Harnett County

Permit Number: EHFL2301-0002

Description: **Rudino's Pizza and Grinders**

SENT DATE	RETURNED DATE	DUE DATE	TYPE	CONTACT	STATUS	REMARKS
Review Group: ALL						
1/17/2023	1/18/2023	1/31/2023	FIRE MARSHAL	Leslie Jackson	DISAPPROVED	See Notes

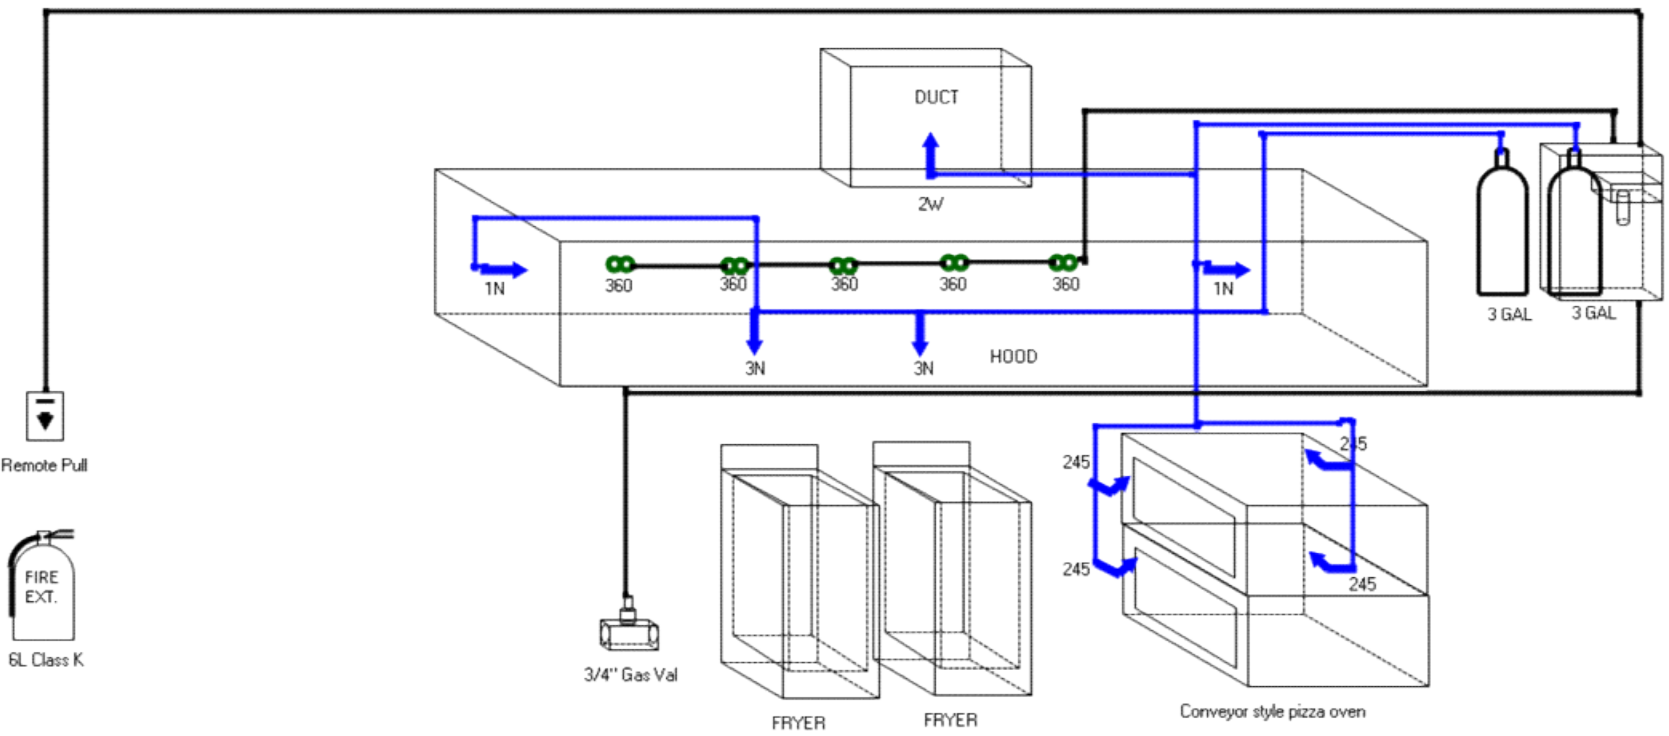
The equipment that is shown when added up is longer than the hood.
